Preferred Project Report - Sydney Water Building, Parramatta

Prepared for: Multiplex

February 2007

Figure 7 – Proposed vehicular access to south-western corner of Sydney Water building (original scheme).

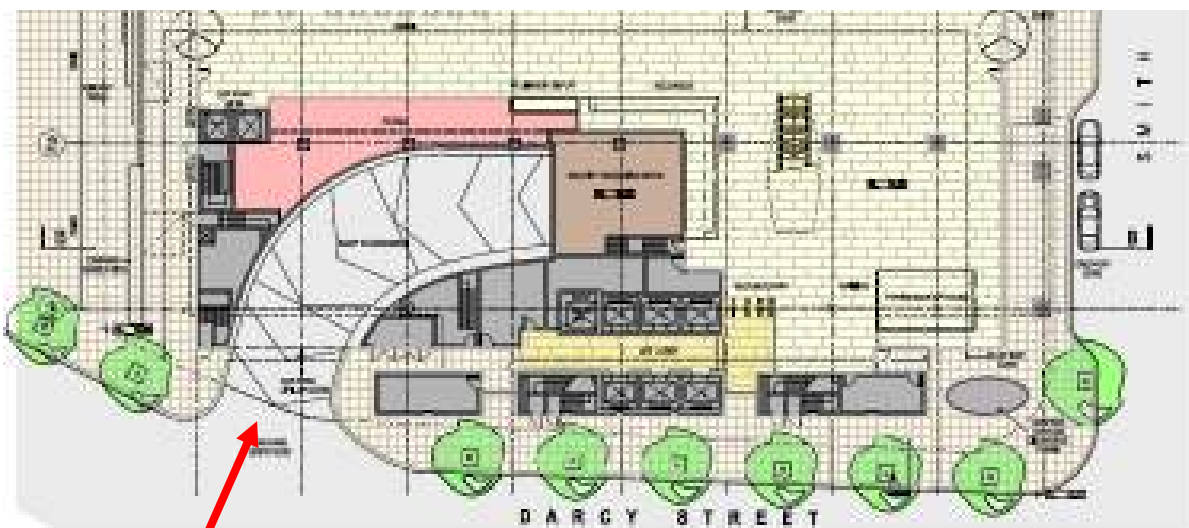
| ISSUES | RESPONSE |
|---|--|
| <p>Vehicular Access</p> <p>The proposed vehicular access to the development at Darcy Street may create conflict with the proposed access to the remainder of the Civic Place development. A co-ordinated solution for access to the subject development and the development of Civic Place prior to, during construction and post construction should be considered.</p> | <p>Our traffic consultant has prepared a submission identifying how the proposal meets access objectives to the site and to the Civic Place development prior to, during construction and post-construction.</p> <p>Refer to DCM sketches showing the SWC on grade Darcy Street entry remaining as planned for use during construction and after completion of the Sydney Water building. This proposal ensures that the goals of both developments are met and respects all known title boundaries for SWC and Railcorp.</p> <p>In addition, we have reviewed our basement design to allow provision of a connection at RL 8.2 at the north-eastern corner of the site from the Civic Place such that an alternative means of access to the Sydney Water basement levels would be available whenever the Darcy Street works are undertaken and access along Darcy Street was no longer available.</p> <p>Sydney Water would have dedicated access over Darcy Street whilst the Sydney Water building is being constructed;</p> <p>In order to satisfy the likely staged nature of development of Civic Place and the stated need for Darcy Street to be closed for construction of the dive structure in the future, Civic Place developer to provide alternative means of access (24/7) through Civic Place prior to commencement of the dive structure and then maintain unimpeded access through Civic Place during the period of construction of the Darcy Street dive structure;</p> <p>Sydney Water would require that PCC / Grocon freely grant right-of-way over the land within Civic Place;</p> <p>Sydney Water would have right-of-way / shared access to the Civic Place dive structure once completed;</p> |

| ISSUES | RESPONSE |
|--|--|
| a) South-Western Corner and Western Façade/Pedestrian Access The car park/loading access has a negative visual impact to the square and the train station, generating conflict with pedestrian activity. In addition, the western ground floor interface of the building lacks active uses | <p>The car park entry is 10m wide and 4.5m high to facilitate both car and truck access into the SWC site. The overall width of the opening is dictated by vehicle turning circles entering and exiting the building. During peak periods of business usage, we anticipate a maximum of 200 vehicle movements per hour and therefore security doors are proposed to remain open during business hours. At other times a security shutter flush with the building façade will be closed, and only operated on an "as required" basis. Service and waste disposal trucks will generally work outside of normal business hours.</p> <p>The car park / loading access is perpendicular to the proposed Station Square and will therefore have minimal visual impact on it.</p> <p>All vehicle movements to and from the Sydney Water building will occur east of the proposed Station Square, therefore having no impact on the pedestrian access between Parramatta Station and both Civic Place and the SWC development. The SWC traffic movements generated in Darcy Street (parking for 248 vehicles) will be far exceeded by those proposed by the future Civic Place development (stated by the Civic Place developer to be vehicle movements for 2,500 car spaces).</p> |

| ISSUES | RESPONSE |
|--|--|
| | Sydney Water would require that a binding easement be registered in favour of the SW headquarters landowner for access via Darcy Street to a permanent vehicular entrance to the SW site in its currently documented position, until an alternative means of access is available through the Civic Place development. |

Figure 10 – Sketch provided by Proponent in Preferred Project Report illustrating agreed upon relocation of the proposed building.

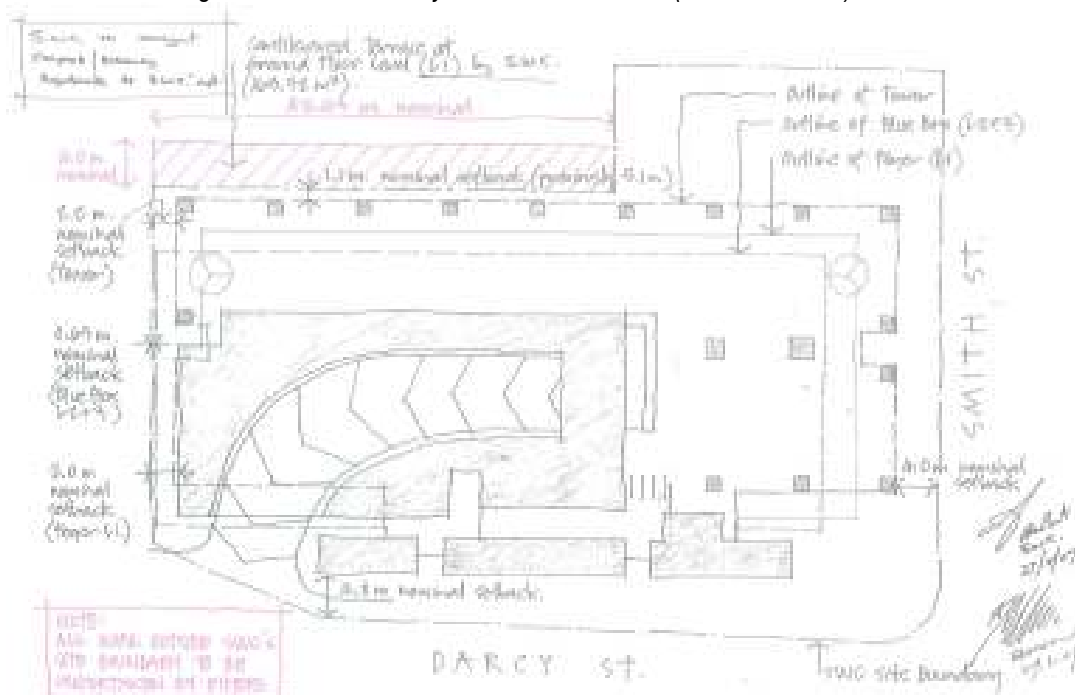
| ISSUES | RESPONSE |
|--|--|
| <p>Solar Access</p> <p>Clause 26(3) of Sydney Regional Environmental Plan No. 28 – Parramatta (SREP 28) requires consideration of the development against the sun access plane control for Lancer Barracks. The height of the building should not exceed the sun access plane, unless it can be demonstrated that the additional overshadowing of the Lancer Barracks is less than 10% of the total site area, and does not create an adverse impact upon the heritage significance of the Barracks. An adequate assessment against this control has not been provided.</p> | <p>We provide details for your review of solar access diagrams. The gross overshadowing of the Lancer Barracks is approximately 6%, less than the 10% total site area referred to. Refer to Appendix D</p> <p>Further as the building is proposed to be moved approximately four (4) metres to the north and to the west, overshadowing effects are reduced.</p> |

Signed copies of Drawings SK204S1 prepared by Denter Corker Marshall & SK 209 prepared by Hassell, which describe the changes to Sydney Water Development & building envelope height limits, are also attached under Appendix A for reference.
